SITE DEVELOPMENT PLAN

2165 JANITELL ROAD

Reviewed by:
Glenn Reese, P.E.
Stormwater Engineer II
GlennReese@ElPasoCo.com
719-675-2654

EPC STORMWATER REVIEW COMMENTS
IN ORANGE BOXES WITH BLACK TEXT

PLAN SHEET
DP 2.1 MVE PROJECT **61195**
MVE DRAWING **DP-PS**

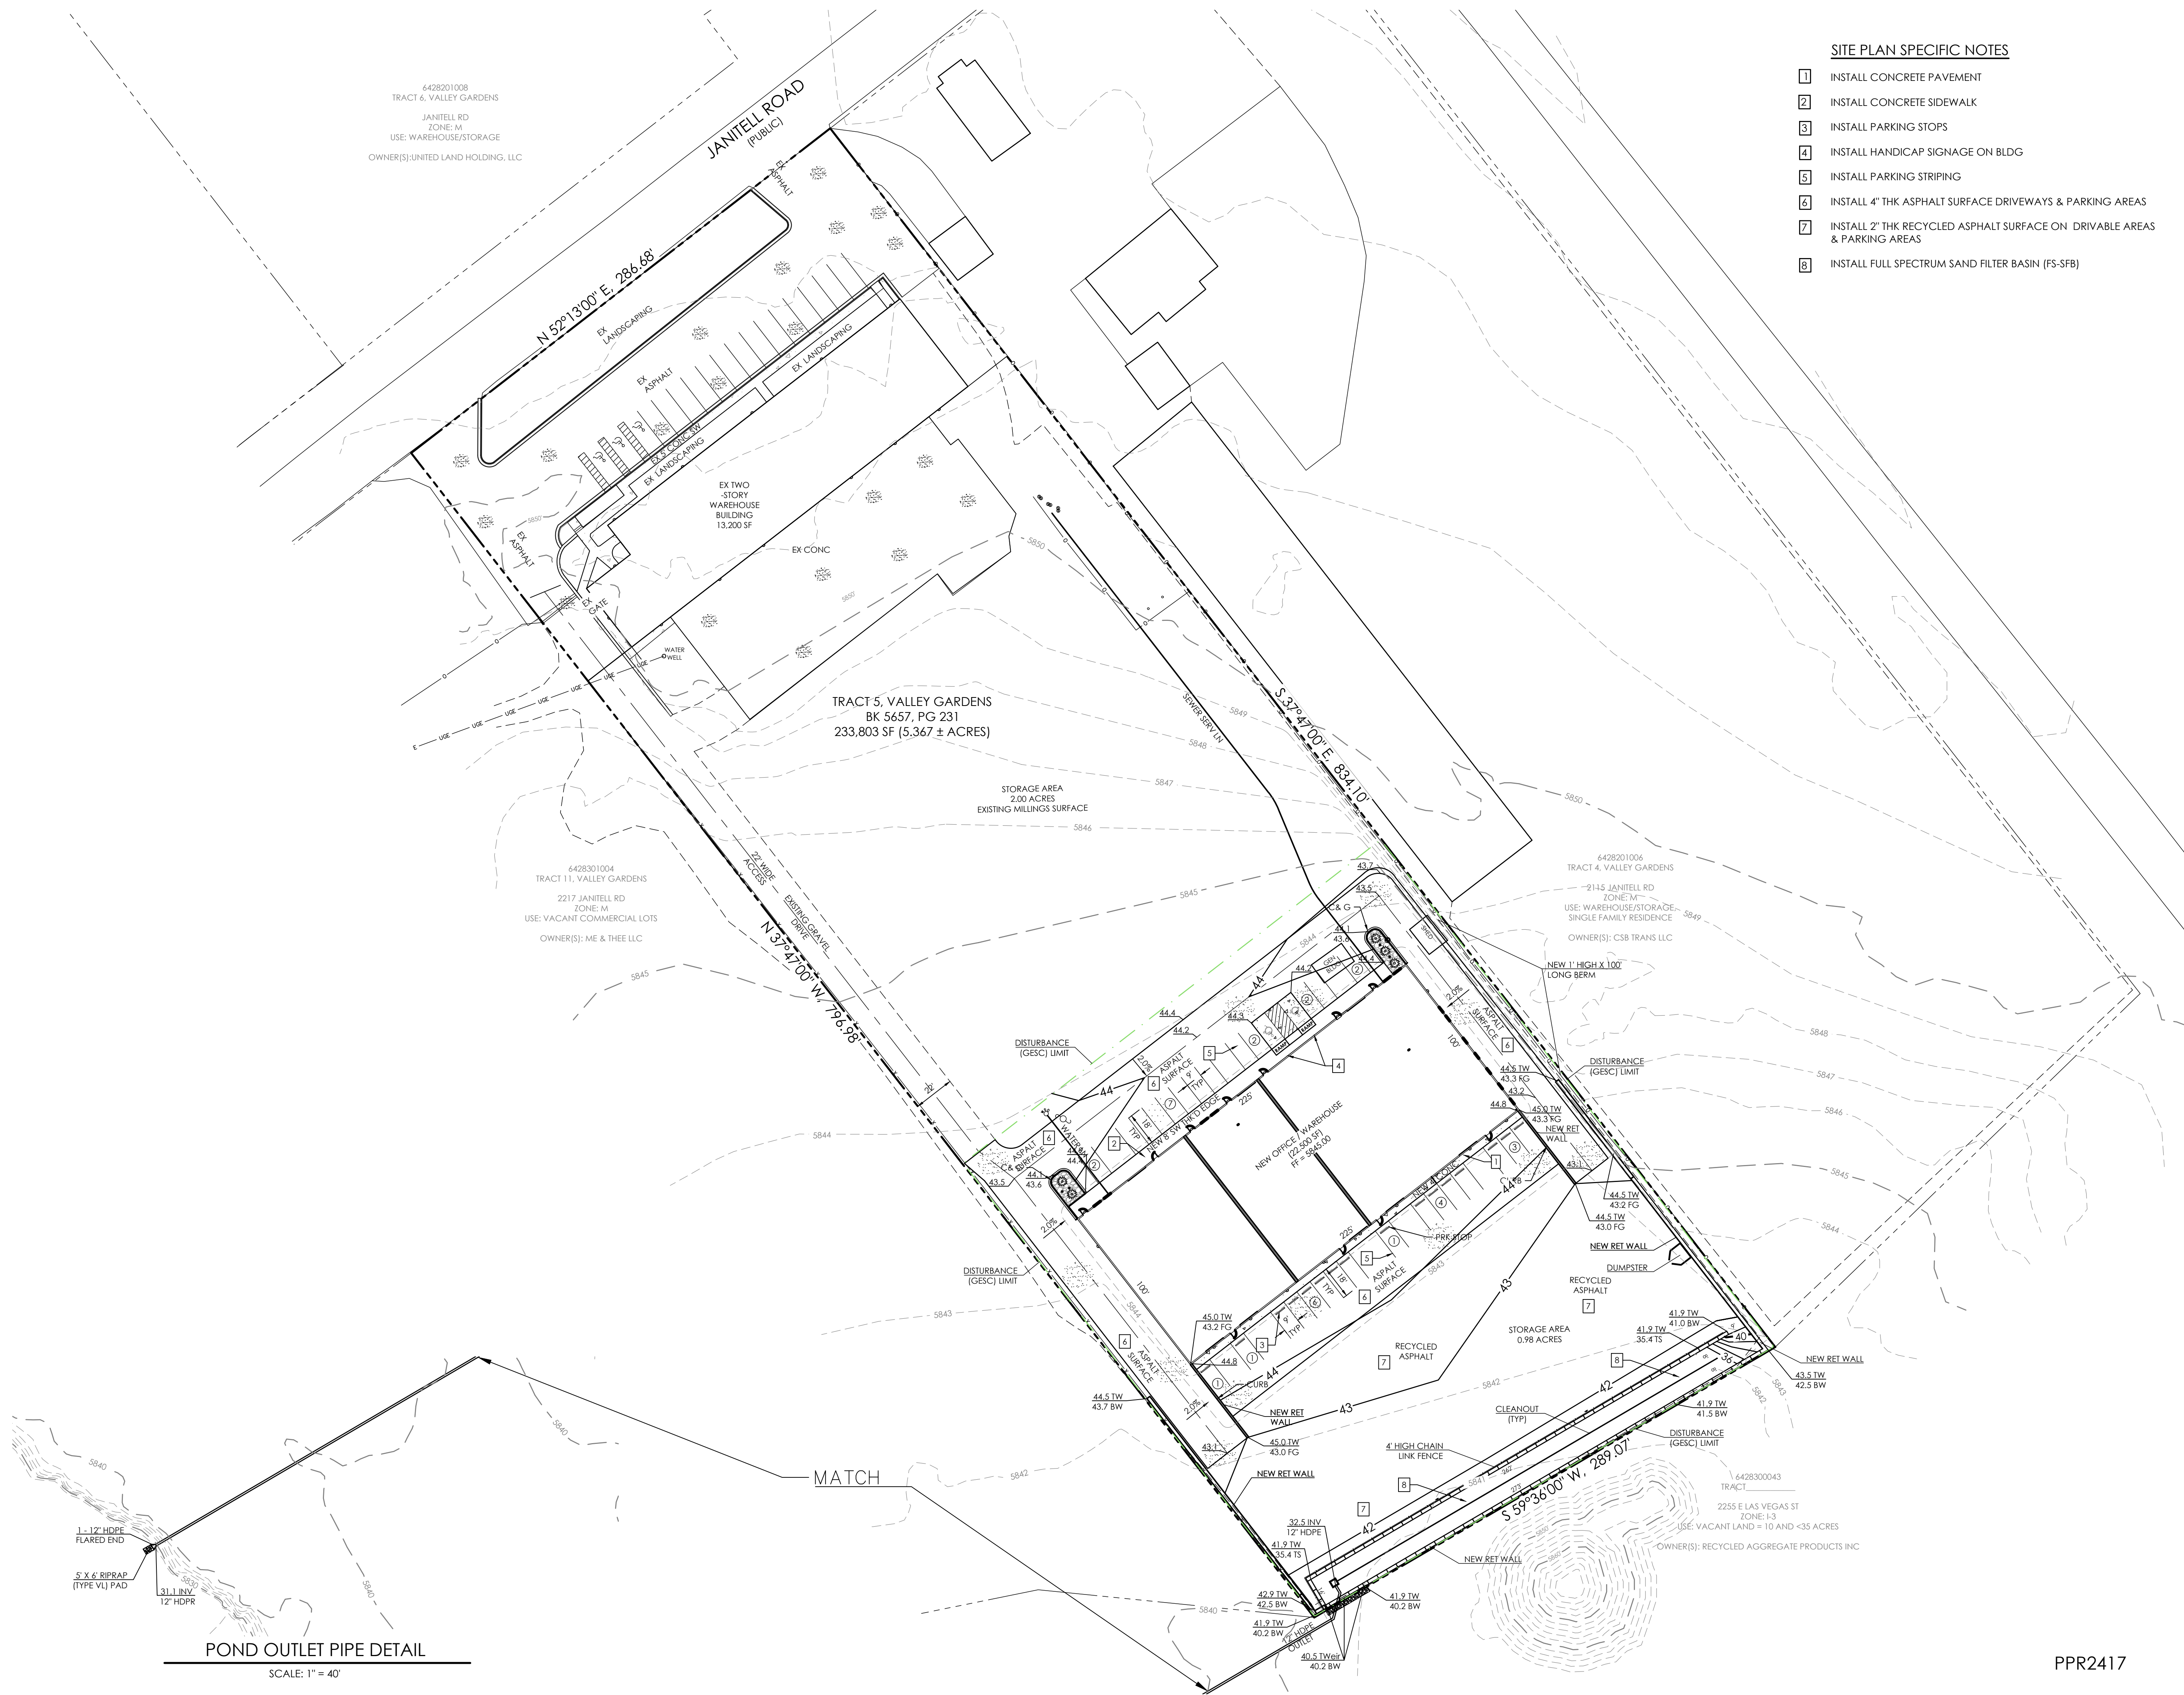
Unresolved comment from Review 1 revised for Review 2:
If scale is 1"=50' (which is what the scale bar shows), then revise the text below it that is 1"=40' Typical comment for all sheets.

Please clarify type of entry sign and provide sign detail.

Unresolved comment from Review 1: label as "proposed gravel"

Clarify what this line is for. It is unclear from the Legend on the previous page.

For clarity, delineate the limits of the 31,295 sq ft of the top storage capacity on here (essentially the limits of the pond).

If this area is to be used for an EDB, it must be vegetated.

Per my phone call with MVE on 7/25/24, they clarified that this area is intended to be used for storage of equipment/vehicles.

However, equipment/vehicles storage is not permitted within the limits of a pond. So if this equipment has to be parked here, then an alternate pond design type should be investigated (for example: underground storage).

DP 3.1 MVE PROJECT **61195**
MVE DRAWING **DP-PS**

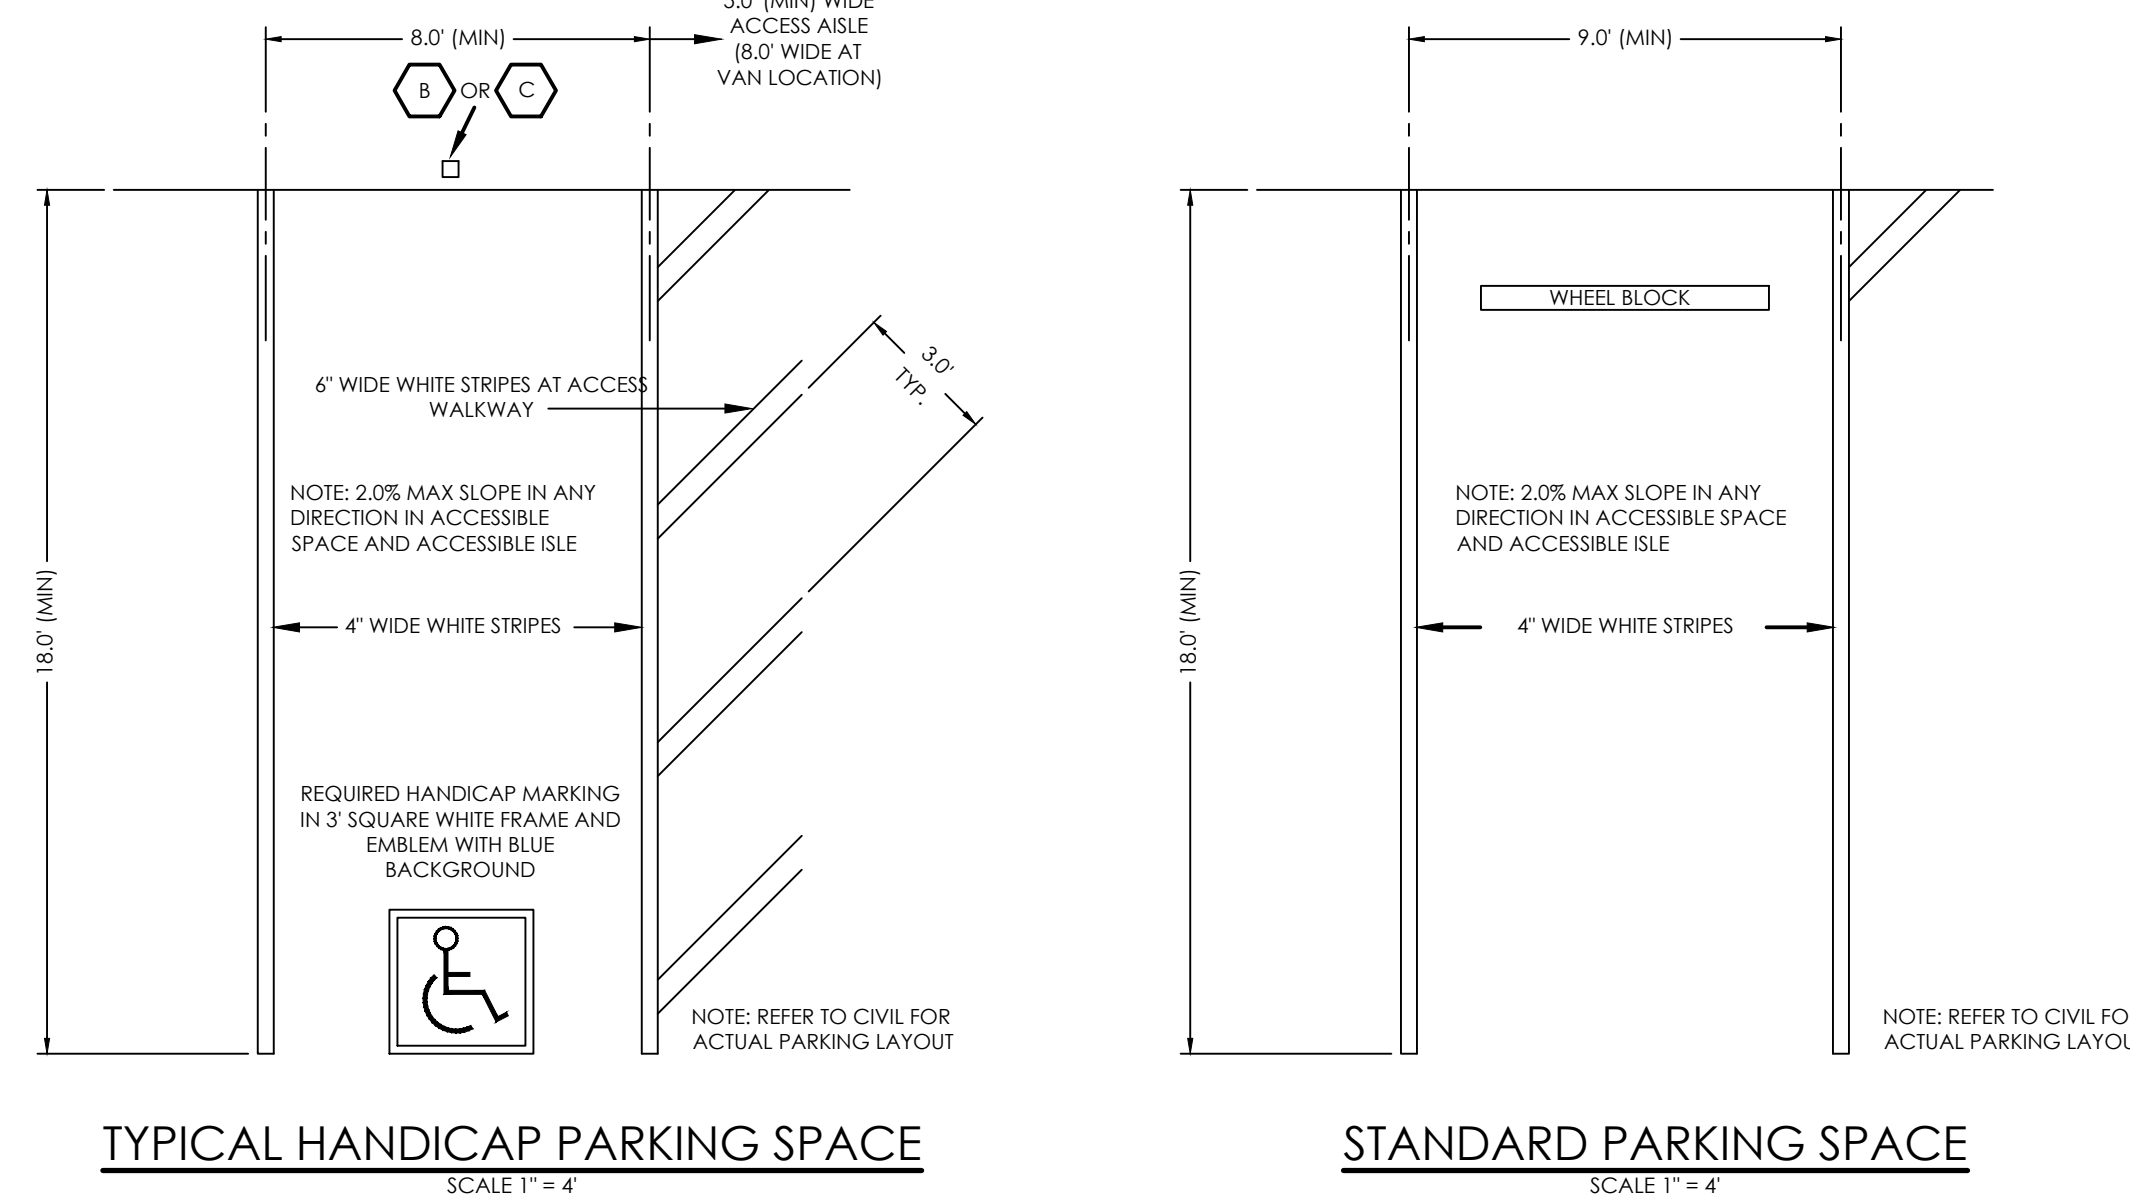
Please provide building setbacks on all sides

DP 4.1 MVE PROJECT 61206
MVE DRAWING DP-DS
DECEMBER 6, 2024
SHEET 4 OF 11

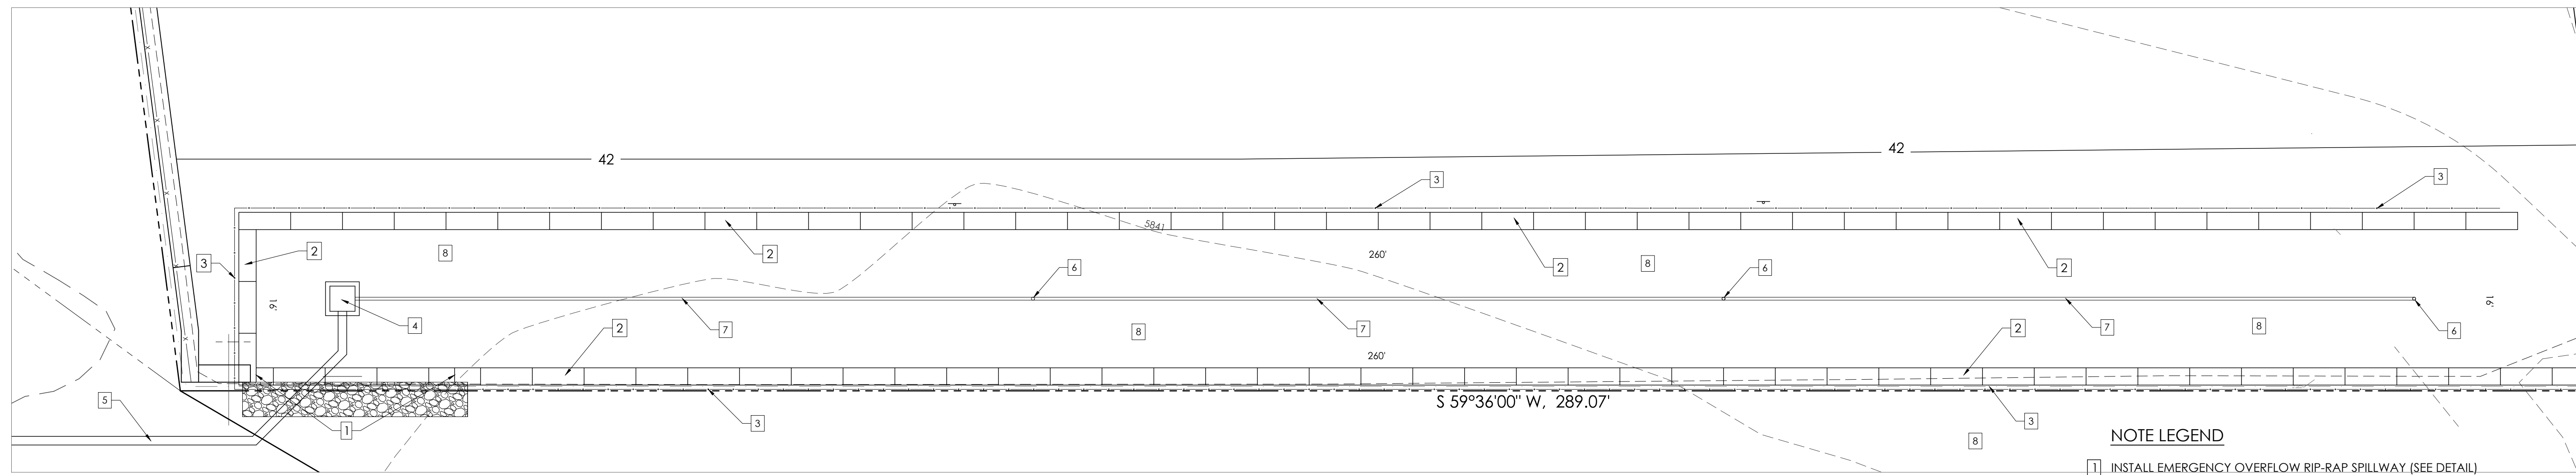
Provide standard parking space dimension detail (detail 11?)

Any new signage proposed? It appears that signage either exists or is proposed in landscape areas near entrance drives.
